Engineers Comments Regarding Surface Water Drainage

Application Reference:	P/69/26/DOC	Reviewer Reference:	ADC/EXT2/D2134/109
Planning Officer:	Simon Brooksbank	Date of Review:	09.07.2026
Site Name:	Land North of Seftor Road & 80 Rose Green Road Pagham		
Application Description:	Approval of details reserved by condition under P/134/16/OUT relating to condition 10- Surface Water Drainage.		
Assessment Number:	1

- Ditch/ Bund Sections and Setting Out Sheet 3. Drg no. 10768/1642 Rev C2.
- Site Sections Proposed Flood Bund Sheet 1. Drg no. 10768/1639 Rev C6

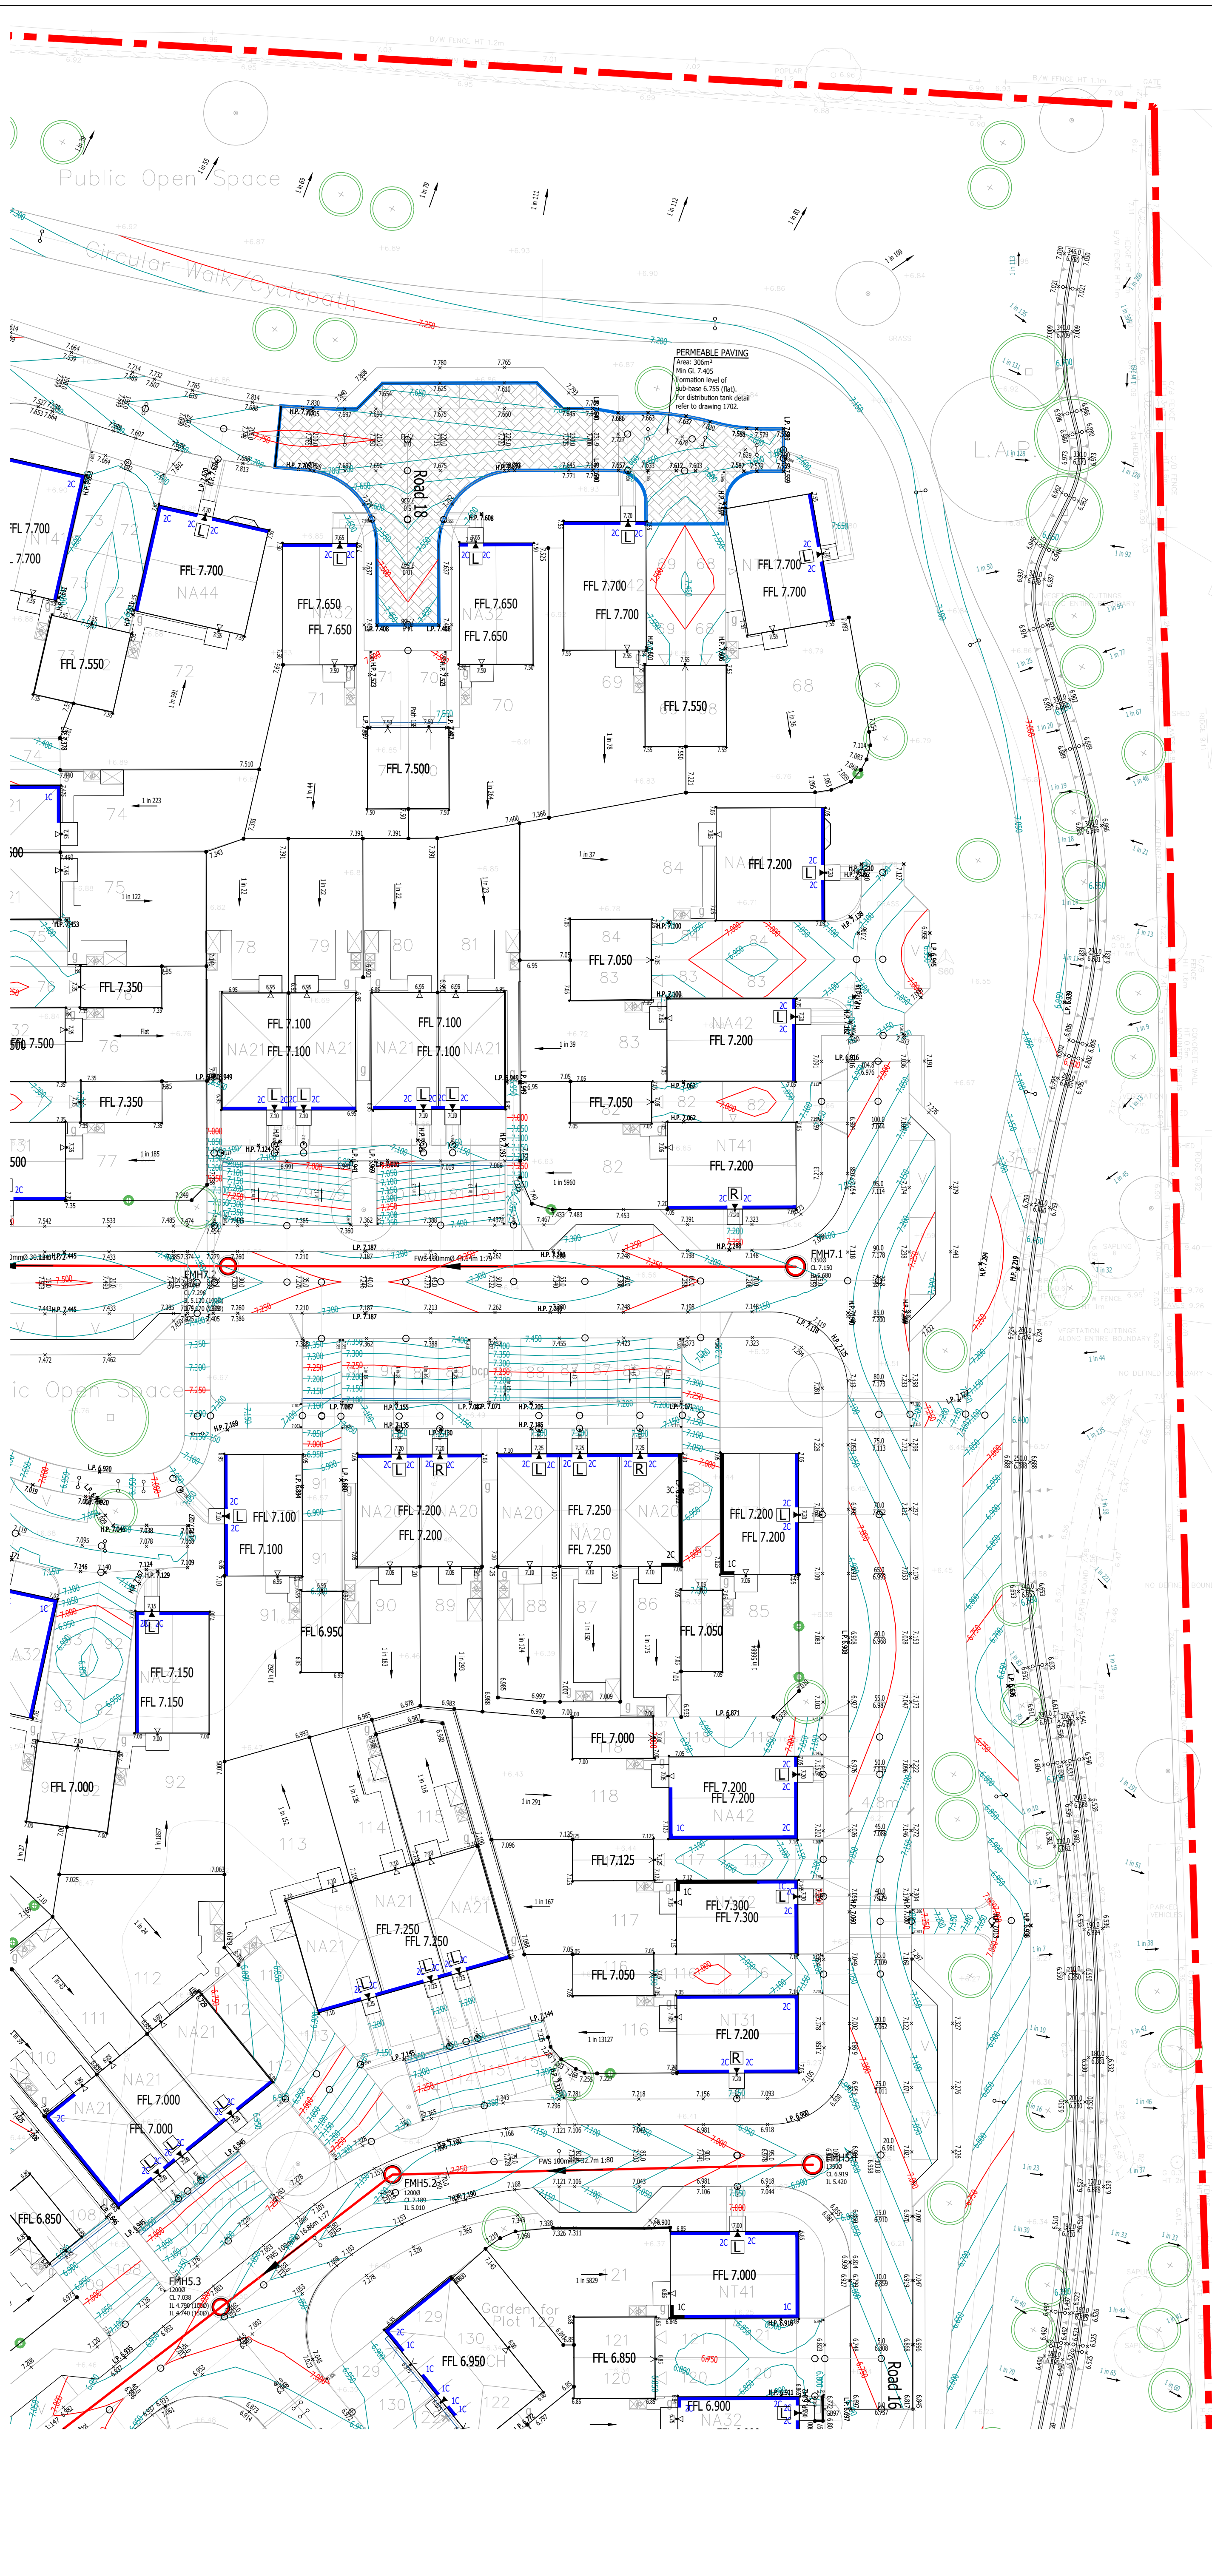
6.			Further to comment 4 above, it is evident that the flood bunds and swale are to provide some mitigation for exceedance flow. Further evidence is require to determine the impacts of these local catchments where this is partially footway (impermeable) and verge (greenfield run-

off). This shall be quantified and re-modelled within the 1D calculations to conclude there is sufficient provision within the receiving SUDS basins/network.		
--	--	--	---	--	--
